Re: 7501 Holly Ave., Guardian Storage

Temporary Certificate of Occupancy – Transportation Development

Re: Guardian Storage-Holly Conceptual Grading and Drainage Plan, Engineer's Stamp Date-no stamp- (C19/D056)

Grading and Drainage Plan

ARCHITECTURAL SITE PLAN FOR BUILDING P GUARDIAN SELF STORAGE

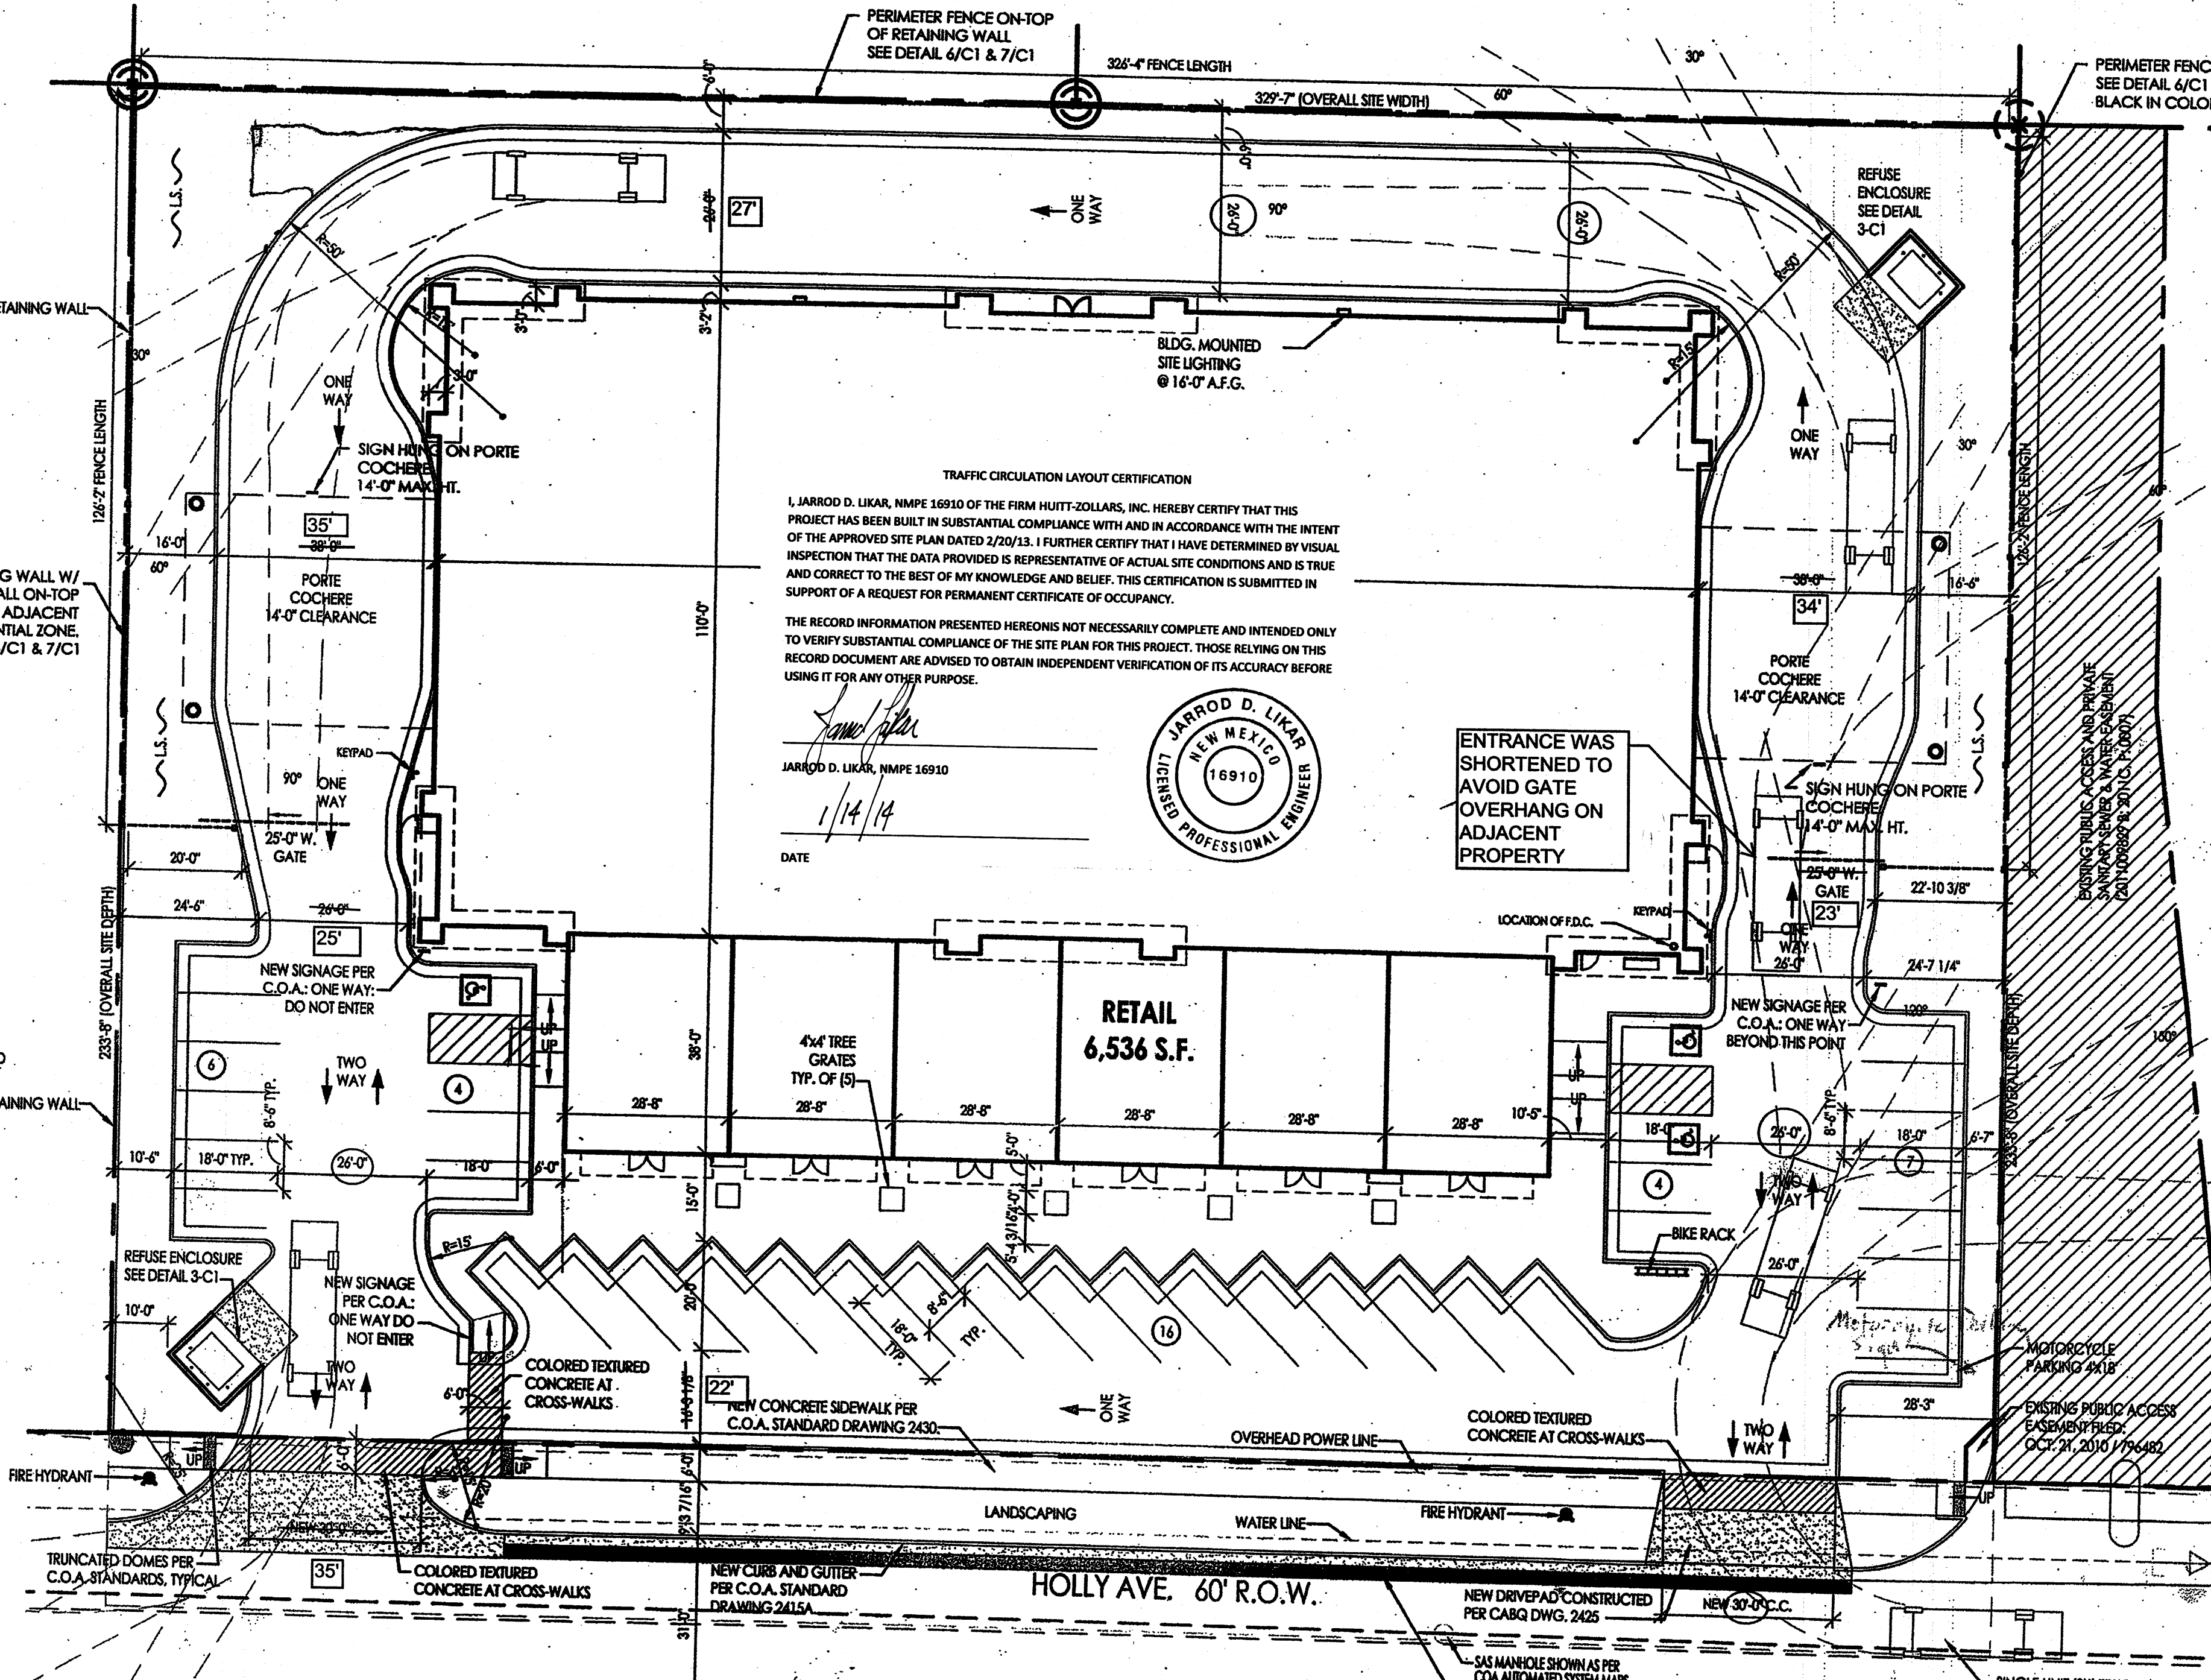
After review of the site we must rescind the Permanent TCL Certificate of Occupancy dated Jan 21, 2014. The fire department required that the area in front of the fire department connection be striped as a no parking lane. This resulted in the loss of a handicap accessible parking space. There was a parking requirement for 37 spaces including 3 HC spaces under the approved Site Development Plan for Building Permit (1009245) which the site does not now meet.

- Relocation of the handicap accessible parking space.
- Completion of an Administrative Amendment for changes to the site plan.
